August 4, 2016

RE: **Freddy's**
131 Coors Blvd NW
Requested for 60 Day Temporary C. O. - Accepted
Engineers Stamp Date 7/7/15 (K10D001B)

Based on the certification provided in your submittal received 8/3/2016, the above referenced is approved for a 60-day Temporary Release of Occupancy by Hydrology. However, before a permanent CO can be accepted the following comments must be addressed.

GRADING AND DRAINAGE PLAN

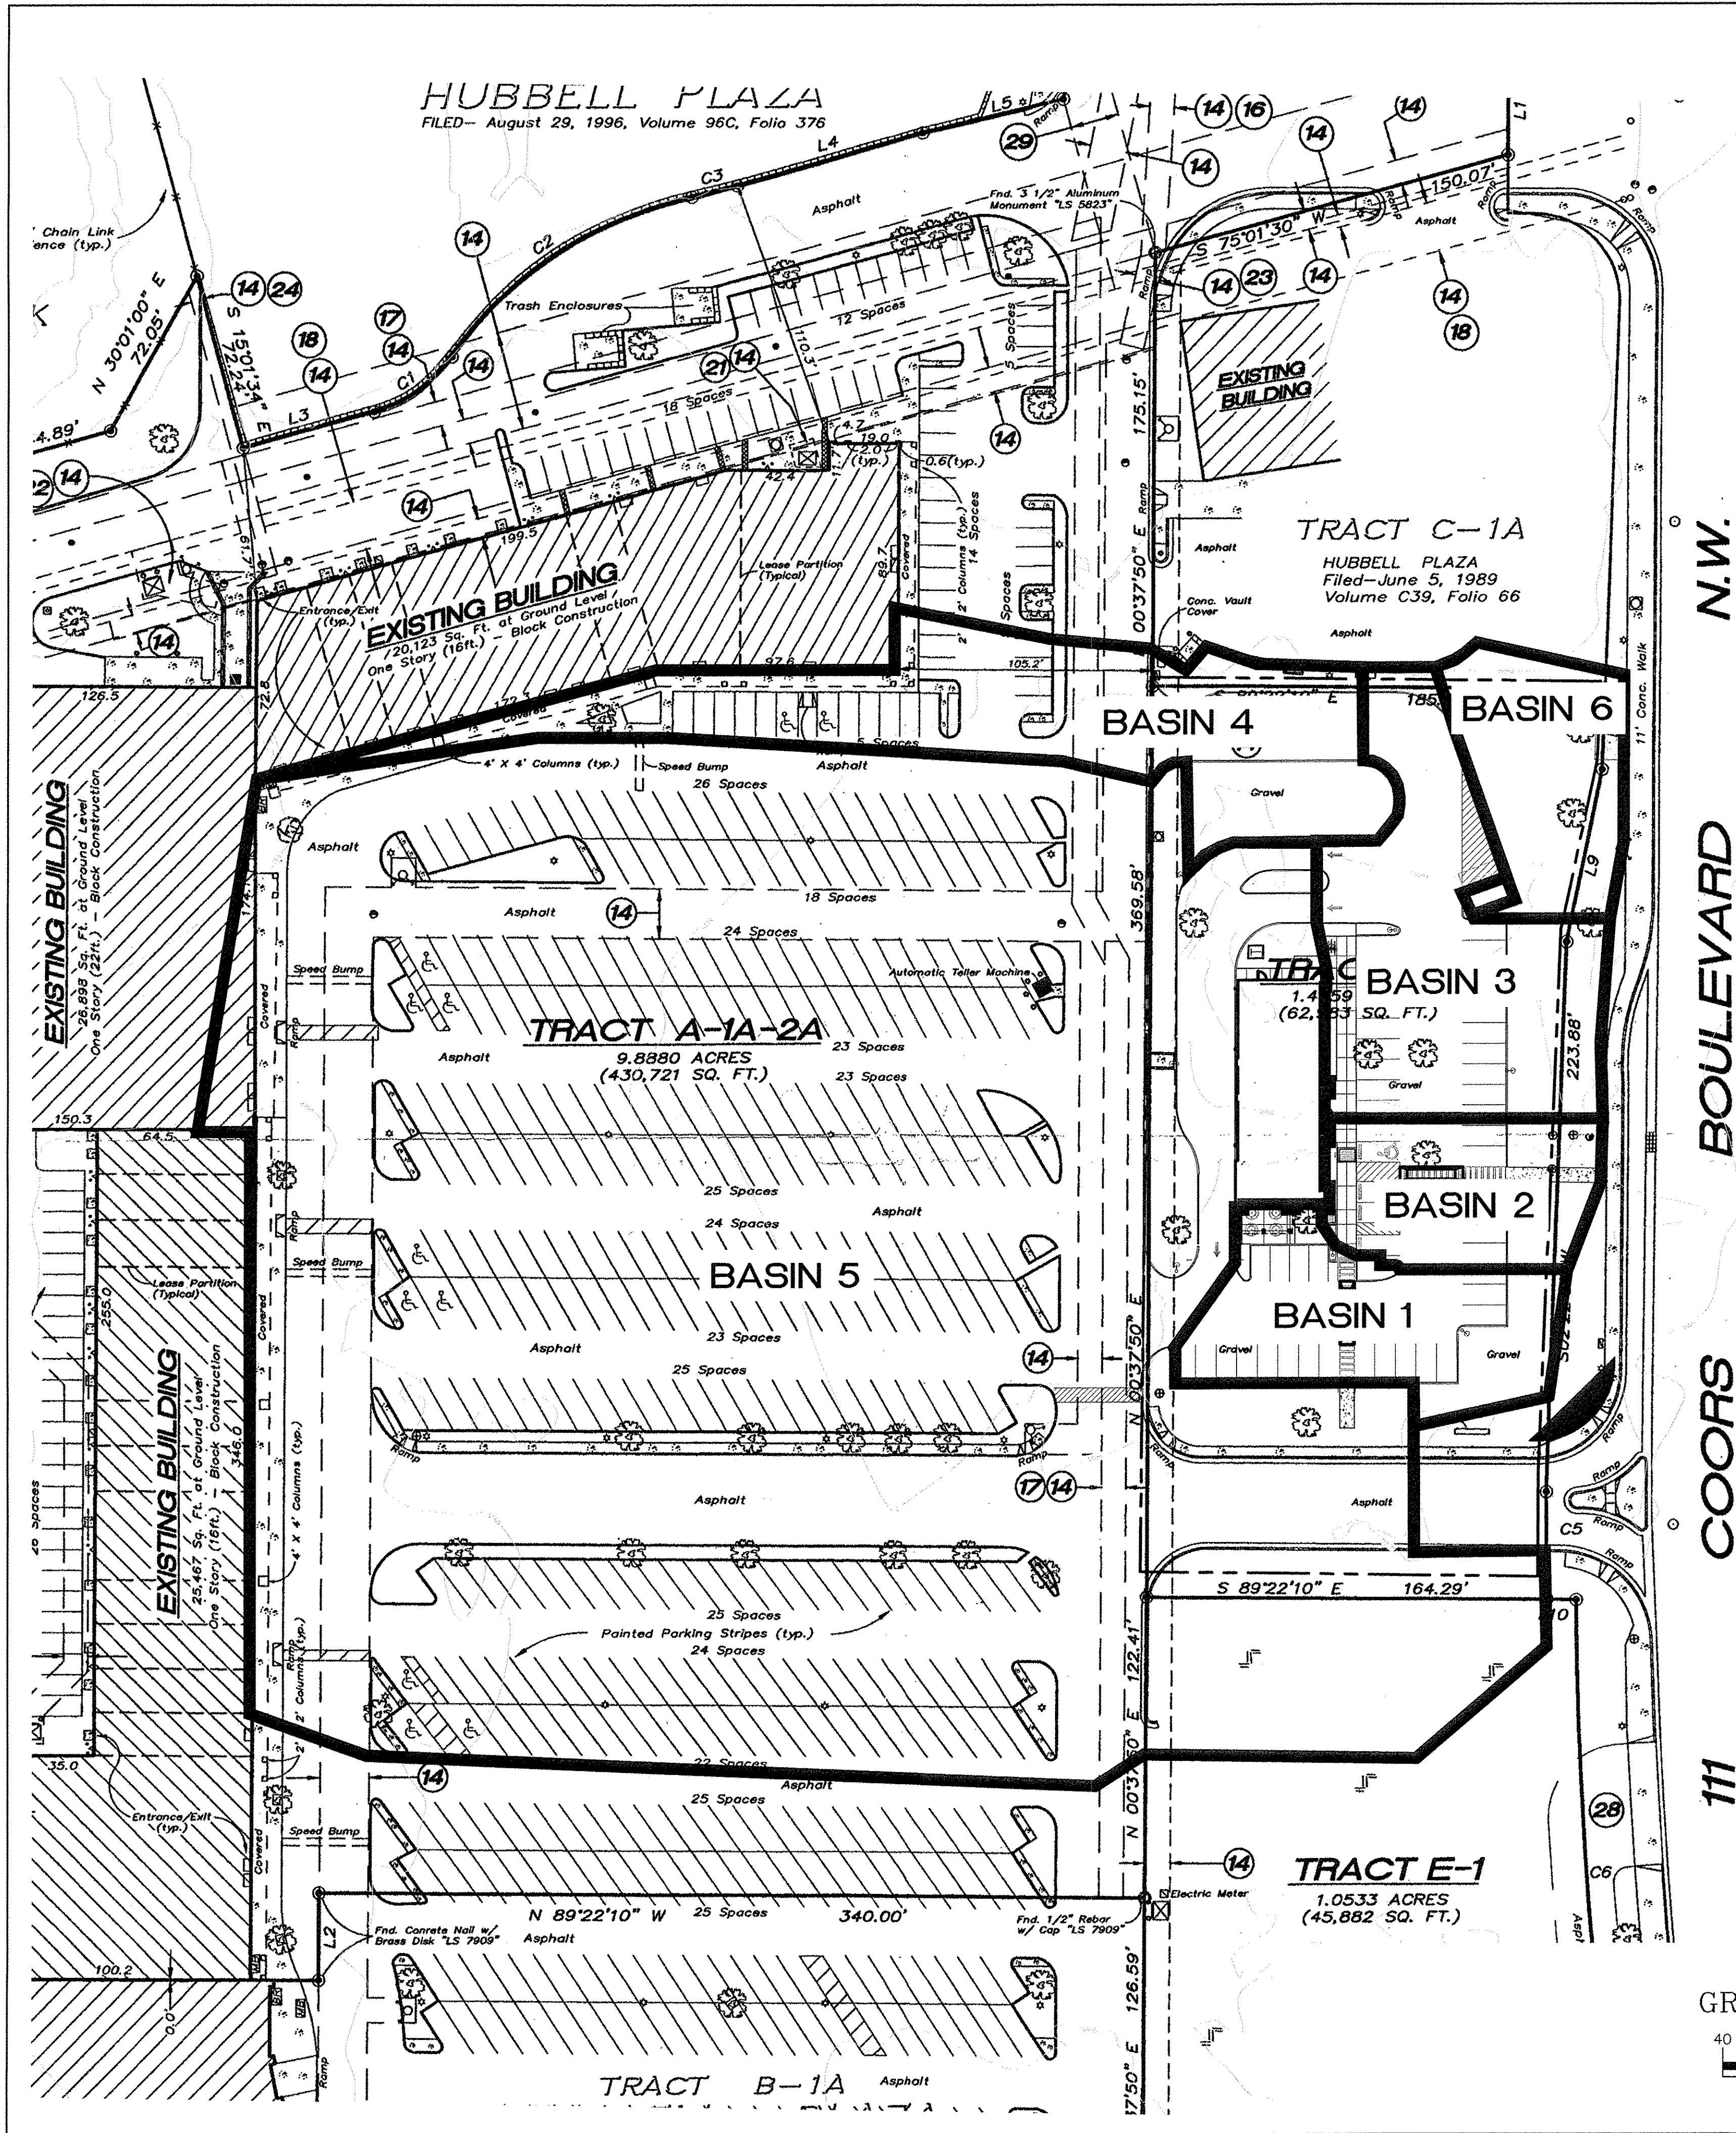
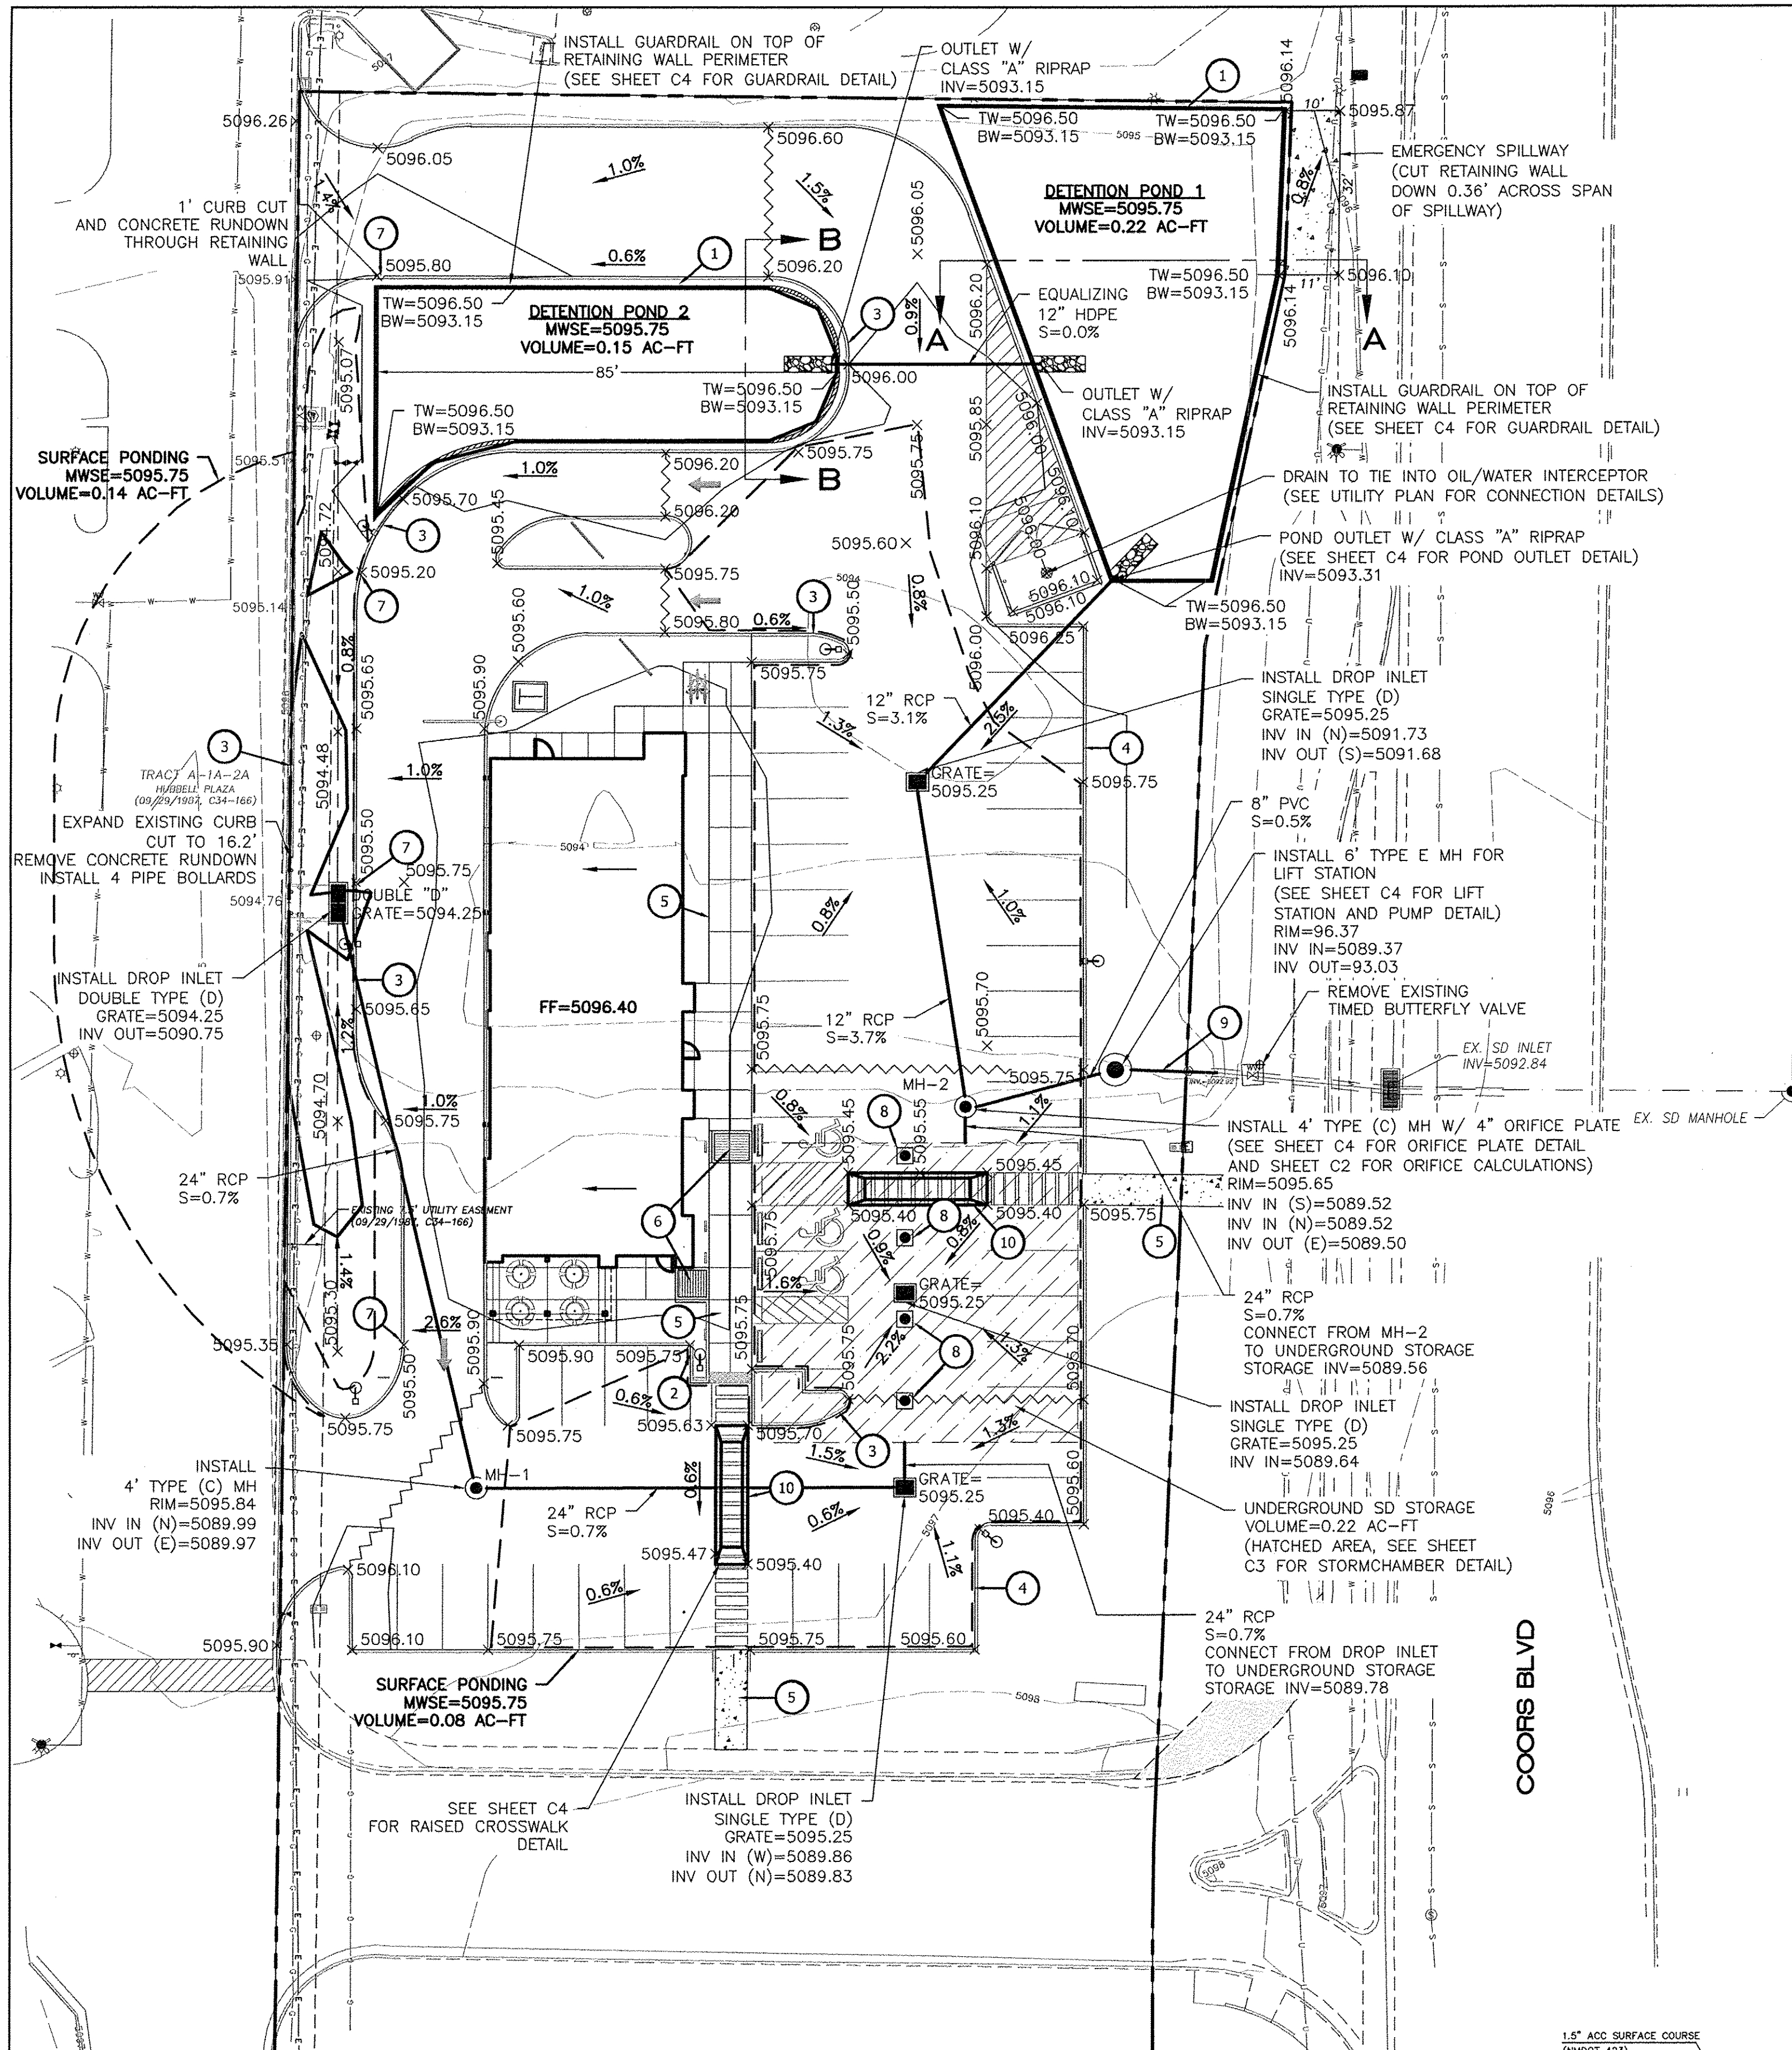
- The concrete spillway must be constructed
